**ANGEL PLACE
LEVEL 8, 123 PITT STREET
SYDNEY NSW 2000**

NIGHT RACING AT ROYAL RANDWICK RACECOURSE -SSD-8706: RESPONSE TO REQUEST FOR ADDITIONAL INFORMATION, MARCH – MAY 2022

We write on behalf of the Australian Turf Club (**the Applicant**) in response to the Department of Planning and Environment's (**DPE**) request for additional information on State Significant Development Application SSD-8706, dated 5 April 2022, 29 April 2022, 9 June 2022 and 22 August 2022. In particular, the request for additional information (**RFI**) refers to issues raised by DPE on the following matters:

Figure 23: New Geometry of Doncaster Avenue / Ascot Street (Priority) Intersection

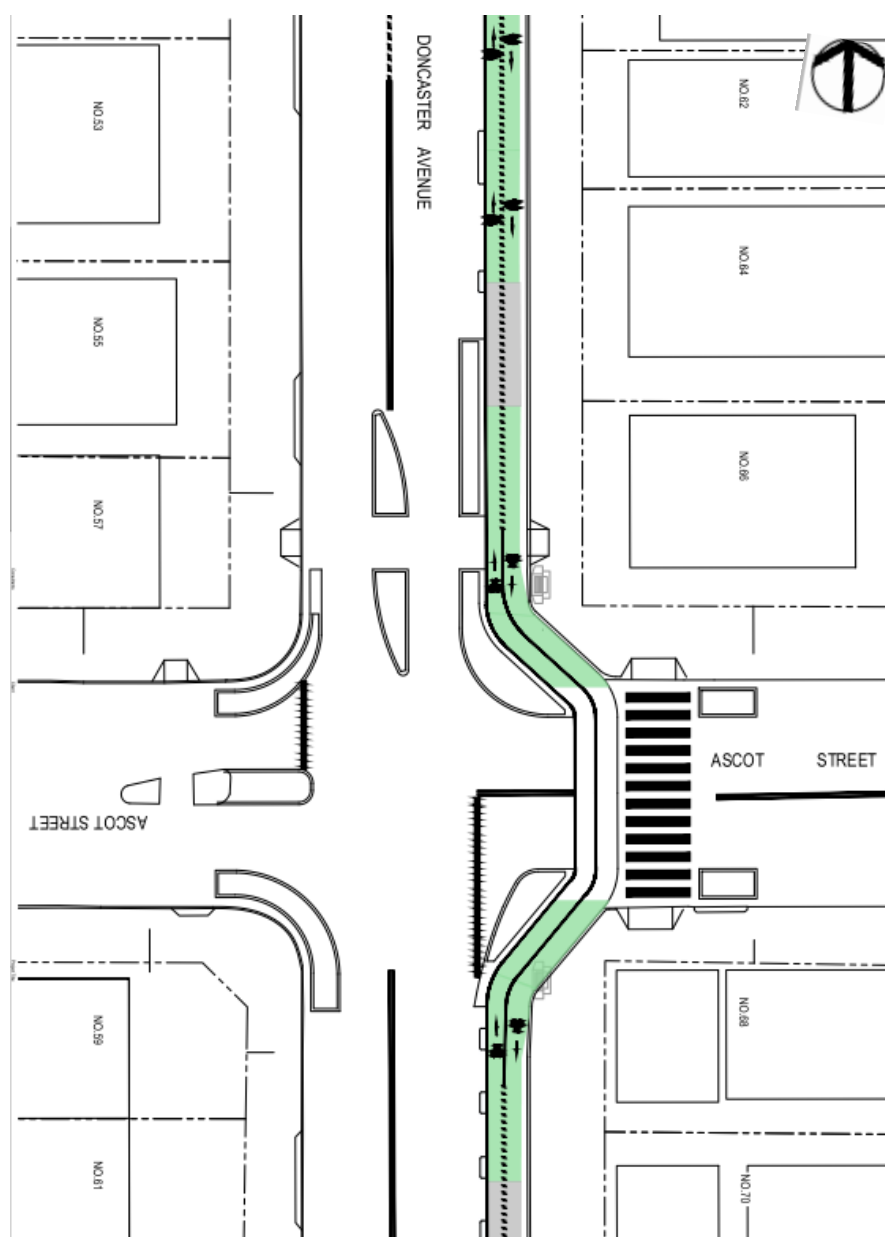
On 9 June 2022 the DPE advised that the RFI response did not adequately address DPE's comments in relation to traffic impacts at the Doncaster Avenue / Ascot Street intersection. DPE requested that the ATC provide the measures proposed to mitigate traffic impacts at this intersection be validated

On 22 August 2022 DPE advised that the updated traffic modelling generally indicates improved intersection performance when compared to the EIS. However, the modelling still indicates significant levels of vehicle queues and delays on the western side of Ascot Street on approach to the members car park (queues of greater than 500m and nearly 10 minute delays).

DPE's traffic consultant modelled a scenario (based on the PTC's traffic model) whereby no traffic is permitted to travel straight across the intersection into the western section of Ascot Street. Instead all traffic entering or exiting the racecourse member's car park must either turn left or right in via Doncaster Avenue. DPE advised that this scenario shows all traffic can be accommodated into the site and the intersection performs at an acceptable level of service. DPE also noted that NSW Police would be present prior to night racing events commencing to manage traffic through this intersection. Police could be instructed not to permit traffic to travel across Ascot Street and instead direct vehicles left onto Doncaster Avenue. Given the car park access is for members only, ATC could also communicate with all members beforehand noting that the car park must be accessed from Doncaster Avenue and not Ascot Street.

- In general, the previous roundabout arrangement of Doncaster Avenue / Ascot Street is considered the better solution for traffic during Racecourse events. The impacts of a Night Racing event on the upgraded priority intersection without additional mitigation measures is significant with worse delays and queues. Applying additional mitigation measures including directing taxis/uber to enter and exit the Racecourse via Gate 1 (Scenario 2) improves the performance of the intersection significantly.

- The former control at the Doncaster Avenue / Ascot Street intersection by means of a roundabout is considered better for traffic management for both general daily use and for the proposed Night Racing events.

- The current arrangement control at the Doncaster Avenue / Ascot Street intersection by means of a priority right of way is considered worse for traffic management for both general daily use and for the proposal Night Racing events.

- For the proposal of Night Racing, ATC and ptc. encourage the support of point duty police with a four-way arrangement at the Ascot Street/Doncaster Avenue intersection, which will also restrict Night Racing event traffic from accessing the western section of Ascot Street.
